Application for a non-material amendment following a grant of planning permission.  
Town and Country Planning Act 1990

ERECTOR OF A SINGLE STOREY EXTENSION

23/01662/FUL

## 8. Non-Material Amendment(s) Sought

PLAN NO: 23/01662/1

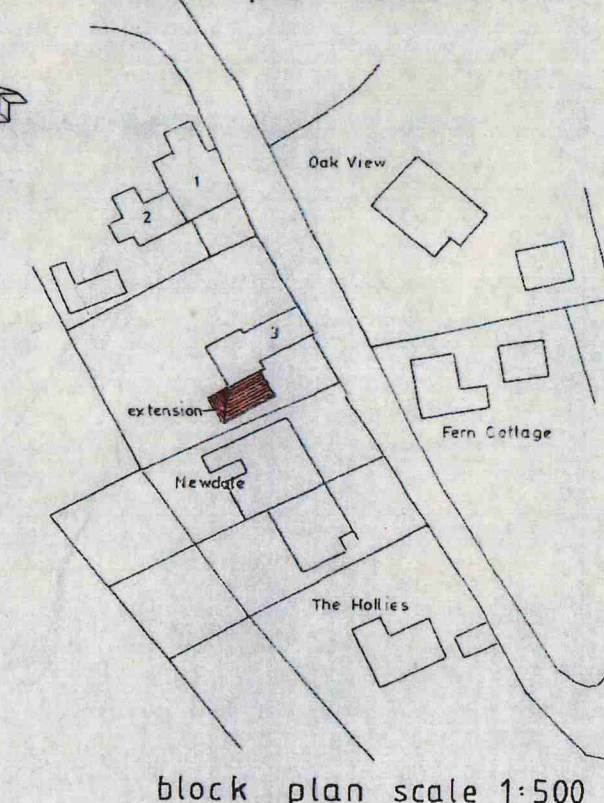
- REDUCE THE DIMENSIONS OF THE EXTENSION BY 2 METRES. NEW DIMENSIONS WILL BE 3600 x 6000.
- REPLACE BI-FOLD DOOR WITH FRENCH DOORS.
- CUT OPENING FOR NEW DOOR AND FRAME WHERE EXISTING WINDOW IS.
- CHANGE USE FROM DINING/KITCHEN TO LOUNGE.

CHANGE THE USE OF THE EXTENSION FROM KITCHEN/DINING TO LOUNGE. WILL NEGATE THE NEED FOR FOUL DRAINS TO BE CONSTRUCTED. THE EXISTING LOUNGE WILL BECOME A KITCHEN AND THE KITCHEN WASTE WILL DISCHARGE TO THE EXISTING FOUL DRAINS.
